Subject: FW: P/15/22/DOC - land rear of Sefter School House, Sefter Road, Pagham

In relation to the re-submissions for the above, please may Environmental Health comment as follows:

From: Kate Giddings
Sent: 25 February 2022 11:42
To: Simon Davis <Simon.Davis@arun.gov.uk>
Cc: Planning.Responses <Planning.Responses@arun.gov.uk>
Subject: P/15/22/DOC - land rear of Sefter School House, Sefter Road, Pagham

Dwg Ref : CMP-01A

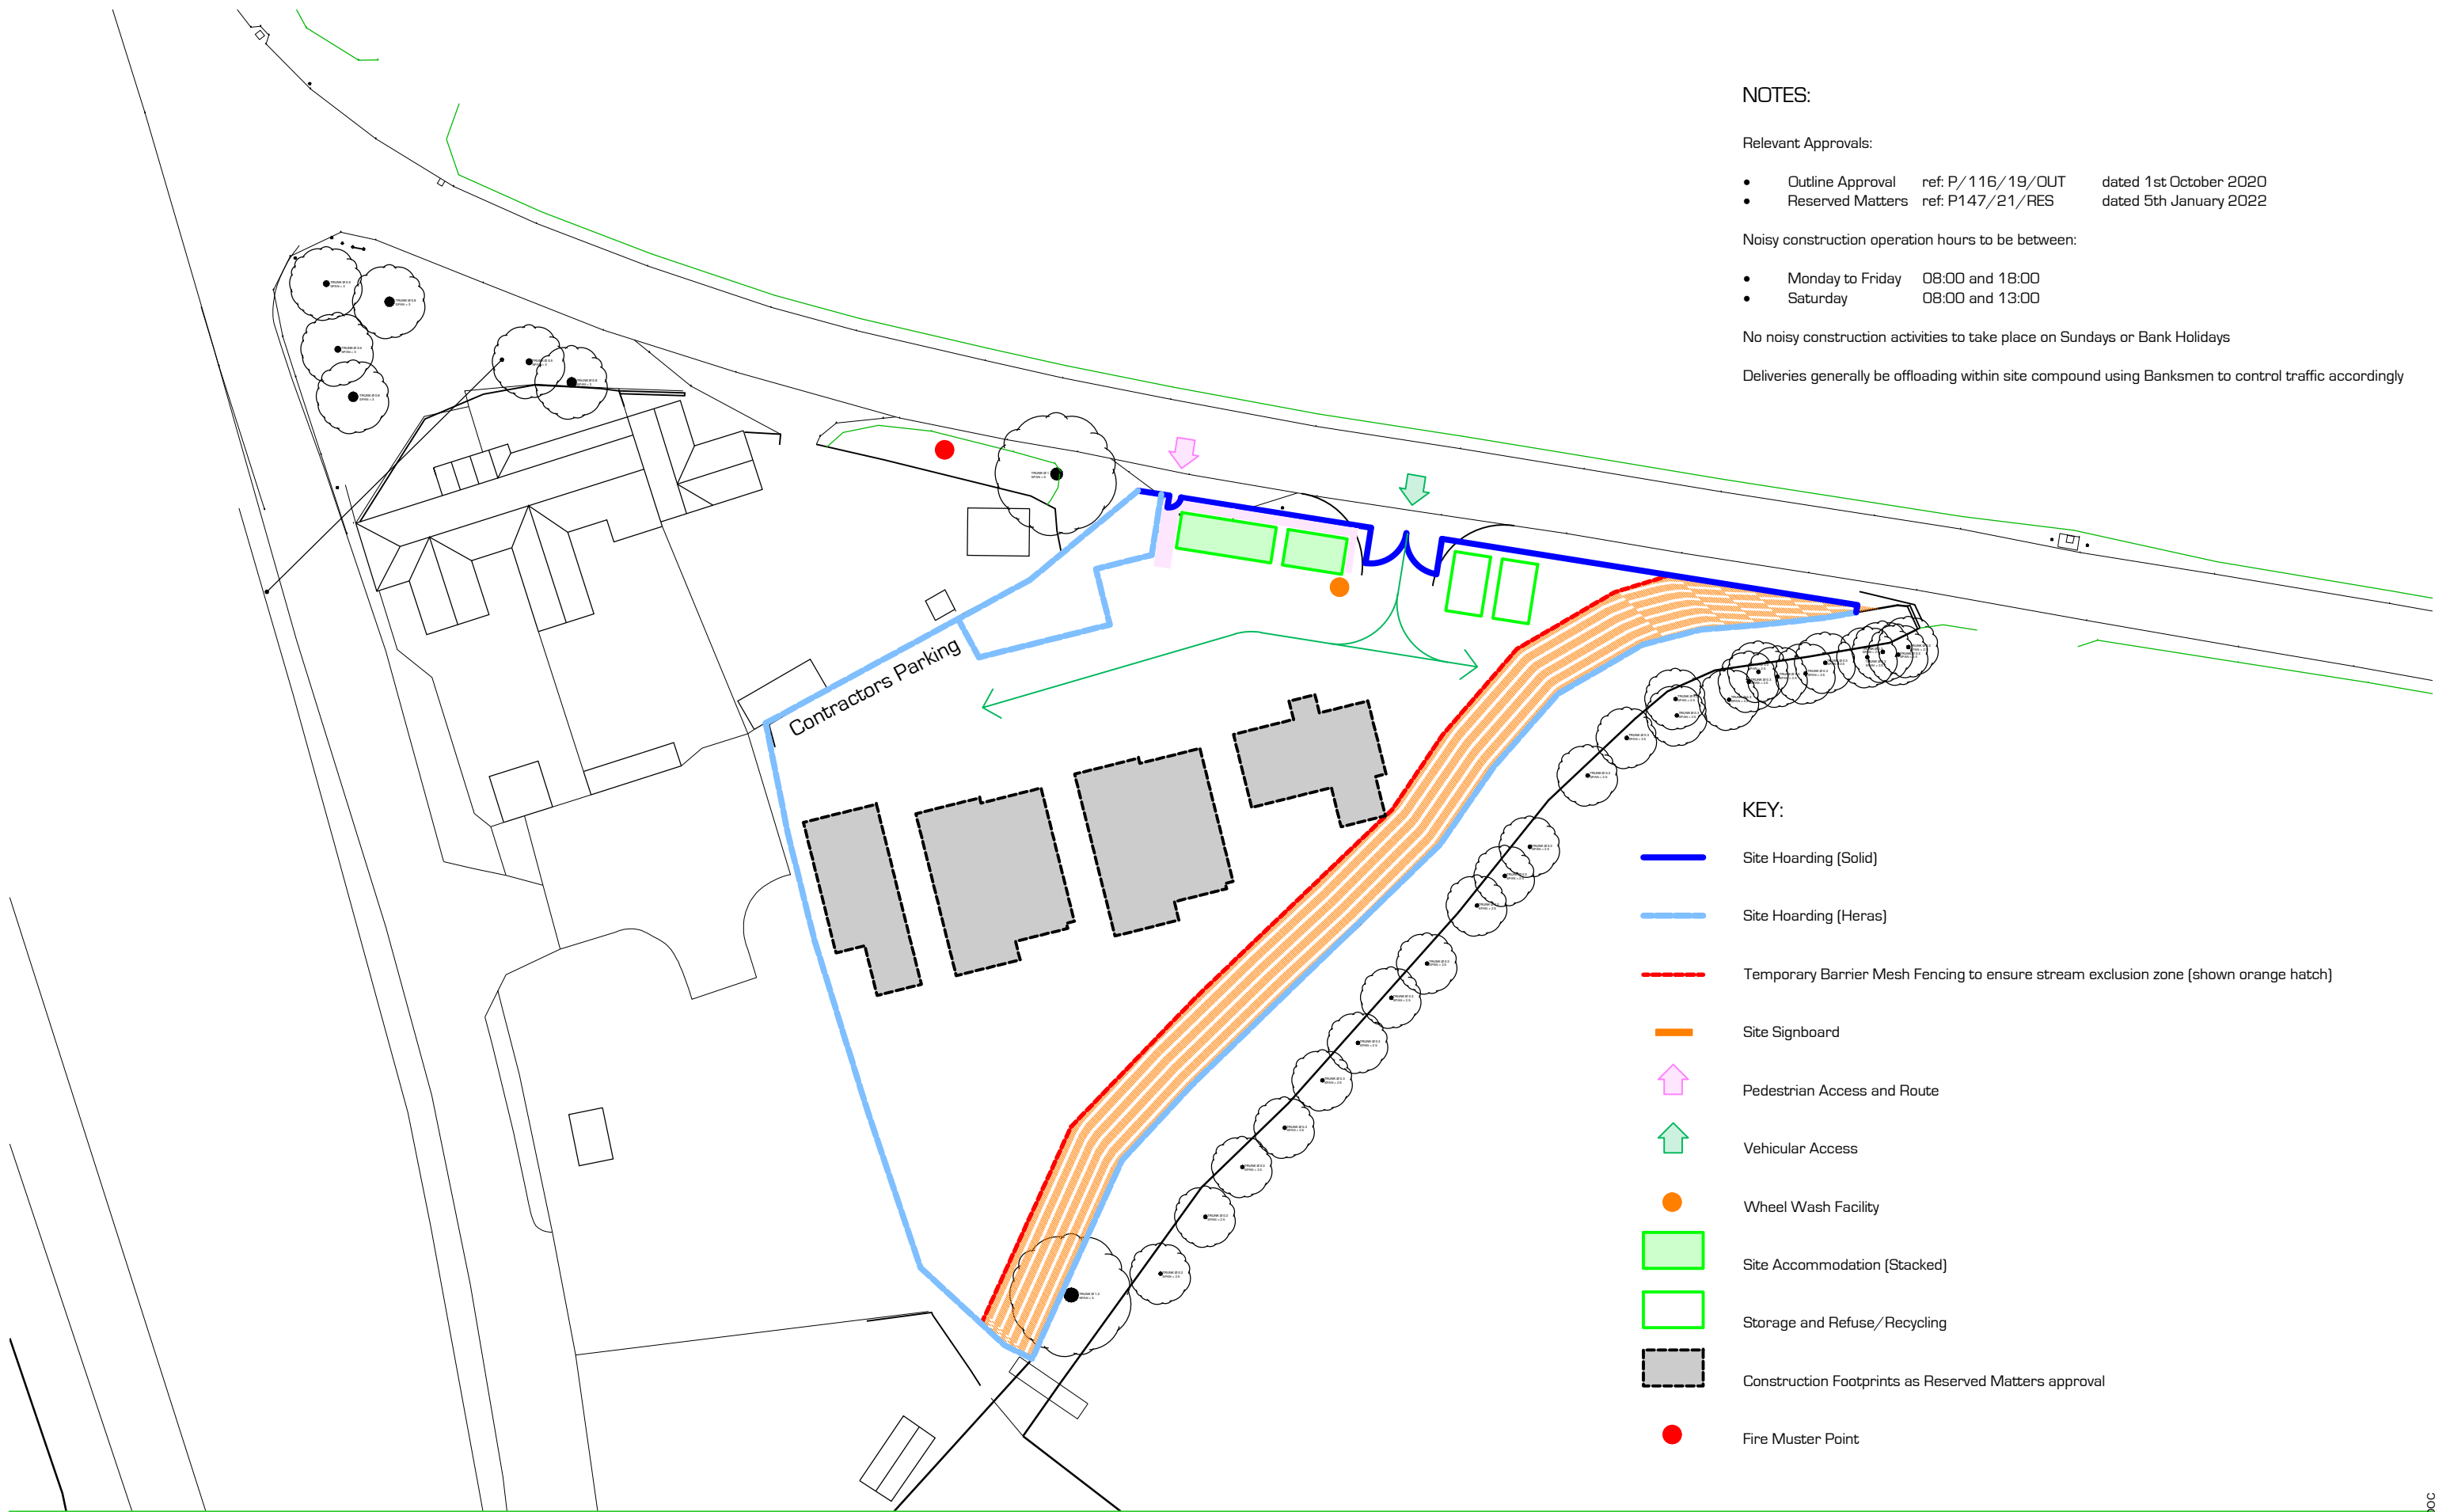
The submission provided (Dwg no. CMP-01A, dated January 2022) does not suitably address the requirements as outlined in the condition, therefore this Department cannot recommend discharge.

Hamilton Homes and Developments Limited's Construction Management Plan document (unreferenced, dated March 2022) is considered satisfactory, although it is noted the postcode of the subject site is incorrect. It is considered that this condition can be discharged.
